Rezoning Transportation Analysis
Petition Number: Insert Zoning Petition #2022-017
General Location Identifier: 03301203

Revision Log:

Date	Description
06-23-22	First Review (PDM)
02-20-24	Second Review (KC)

RZ1.0

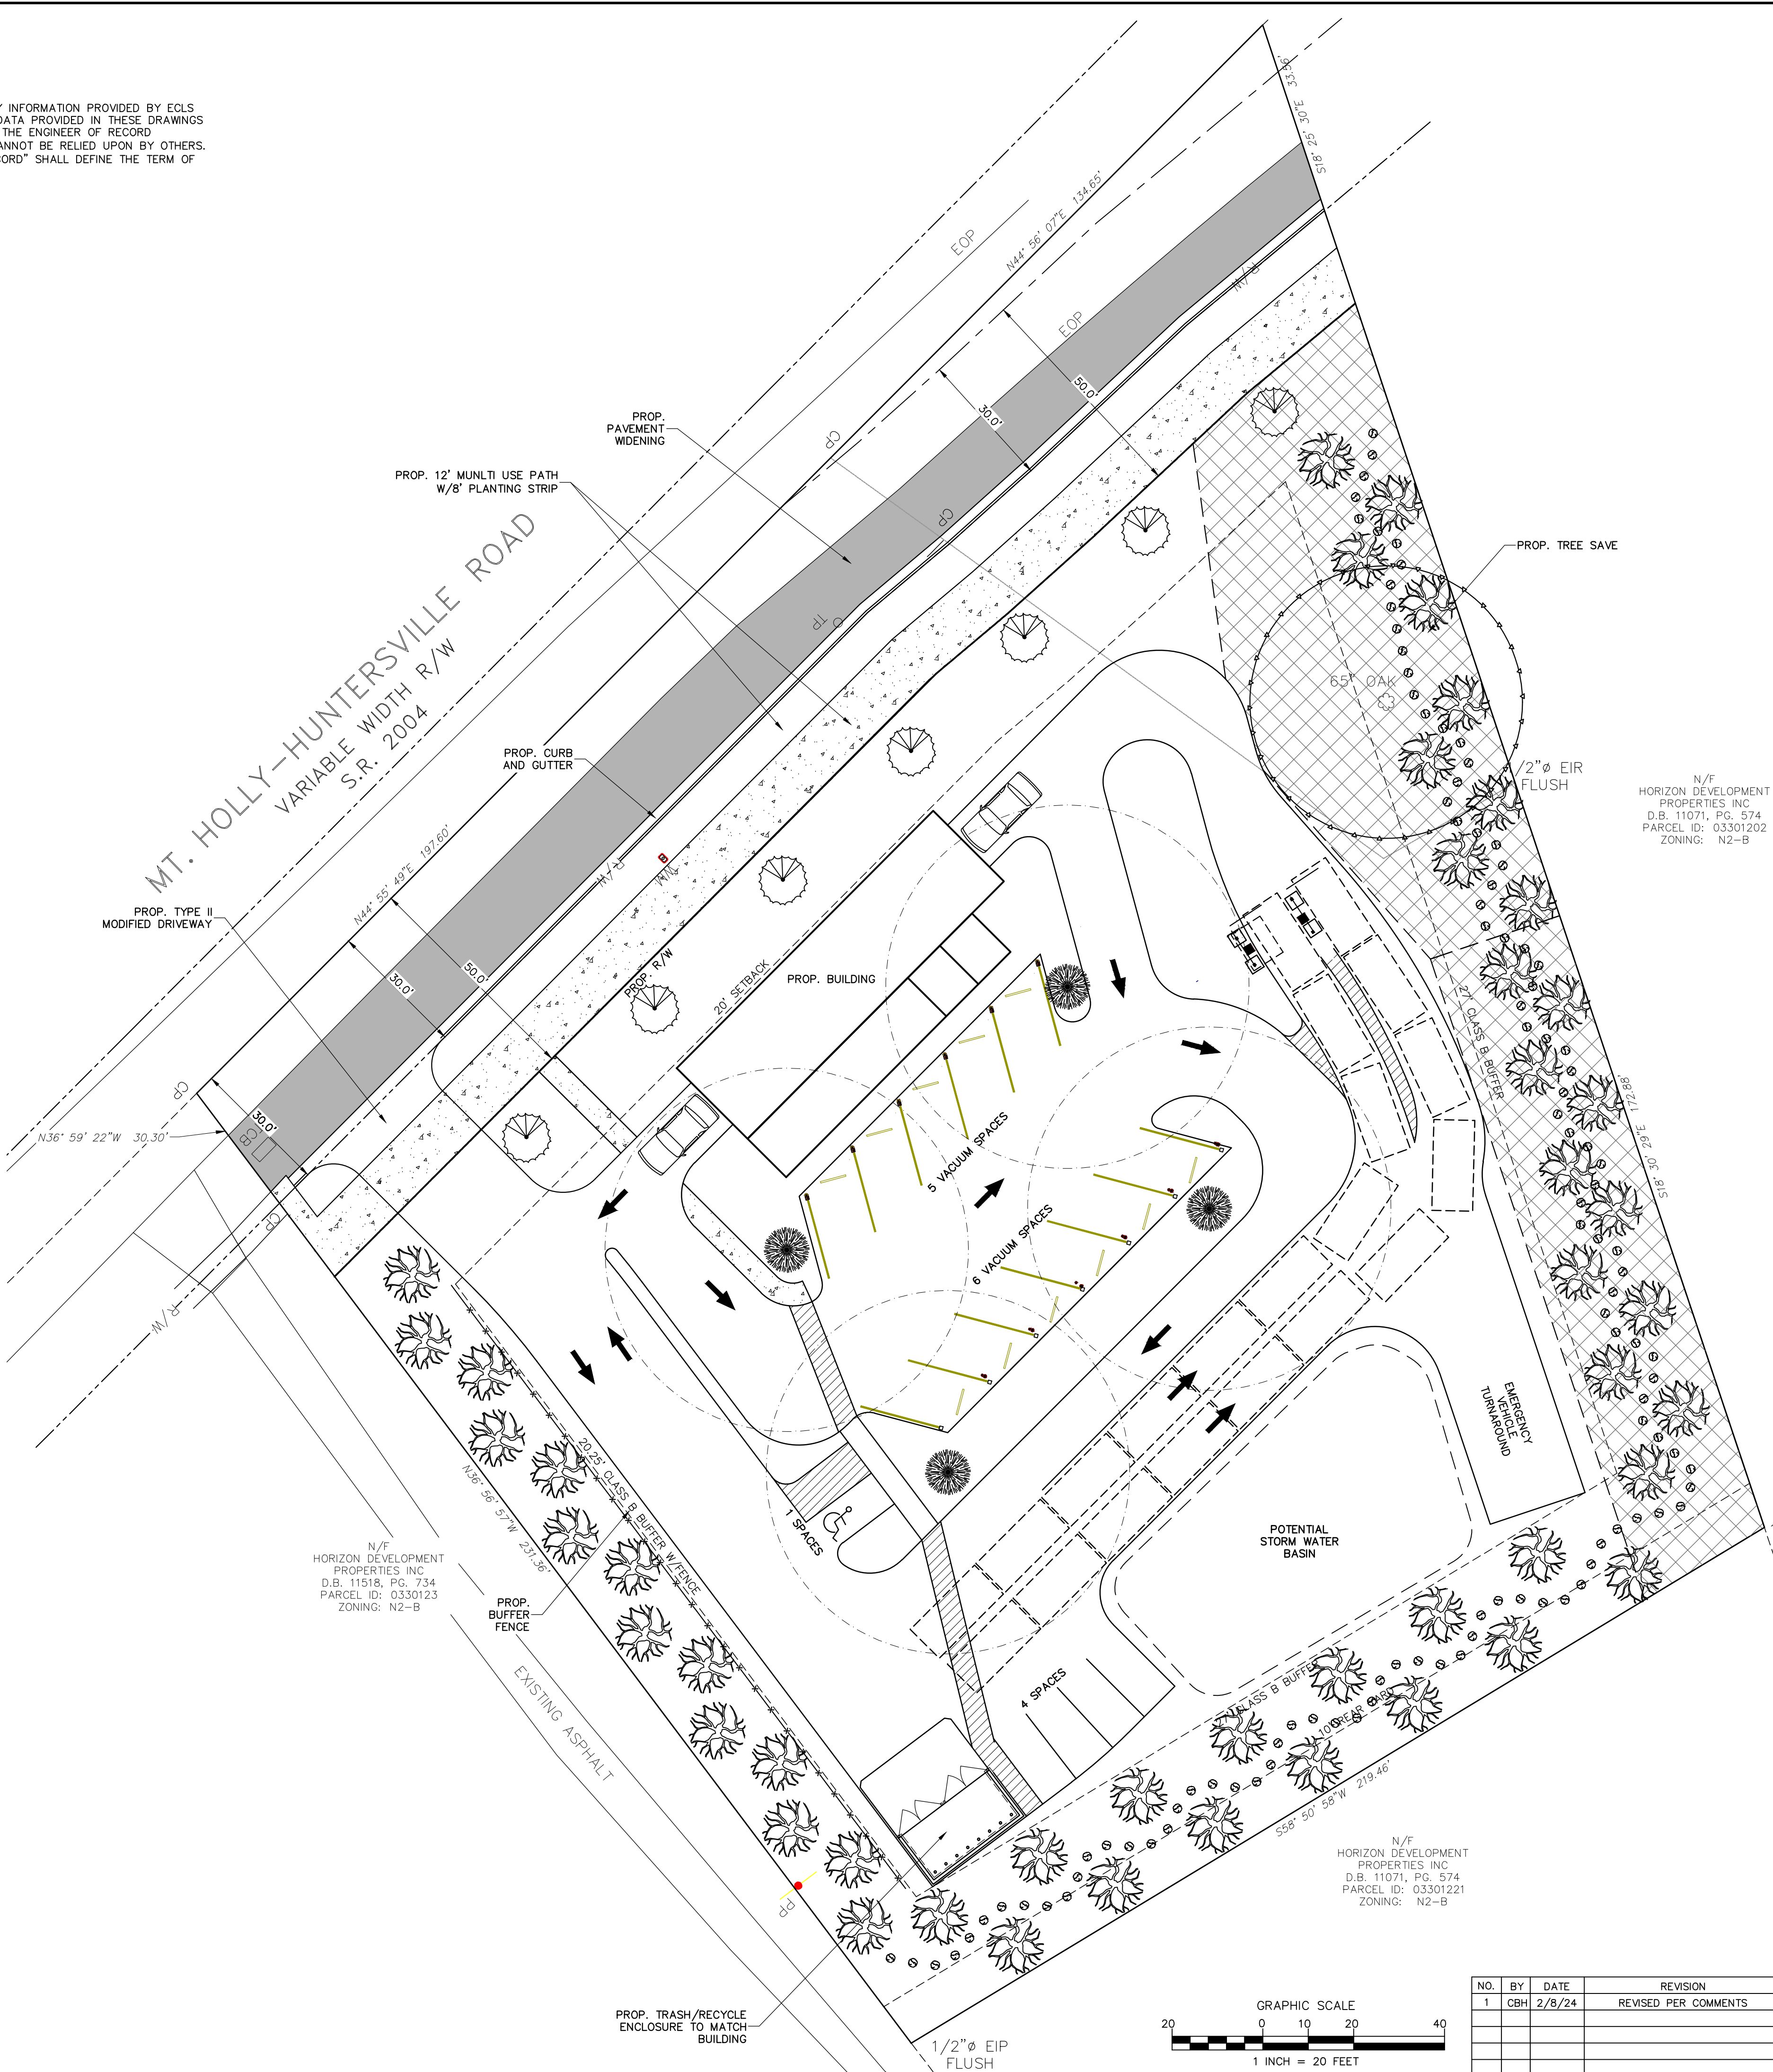
~~2. Revise site plan and conditional note(s) to commit to dedicate 50-foot of right of way from the road centerline. The site plan shall label and dimension the right of way from the road centerline. Show and label the proposed ROW.~~

~~3. Revise site plan and conditional note(s) to commit to installing curb and gutter along the property frontage per Chapter 19. The back of curb shall be located 30-foot from the centerline of the roadway.~~

~~4. Site plan and conditional note(s) revisions are needed to commit to construct bicycle facilities a 12-foot multi-use path to meet the City Charlotte BIKE Policy. The multi-use path shall be located behind an 8-foot planting strip.~~

- ~~5. Per coordination with NCDOT revise site plan to provide a driveway stem with a minimum of 100 feet measured from the proposed right-of-way. No parking shall be located within the protected driveway stem.~~

- ~~6. Remove "if applicable" from the site plan note specifying that all transportation improvements will be approved and constructed before the site's first building certificate of occupancy is issued. The petitioner may phase transportation improvements if said improvements and phasing are explicitly described in site plan notes.~~

- ~~7. Add conditional note "All public roadway improvements will be subject to the standards and criteria of CDOT and NCDOT, as applicable, to the roadway improvements within their respective road system authority. It is understood that such improvements may be undertaken by the Petitioner on its own or in conjunction with other development or roadway projects taking place within the broad northwestern Mecklenburg area, by way of a private/public partnership effort or other public sector project support."~~
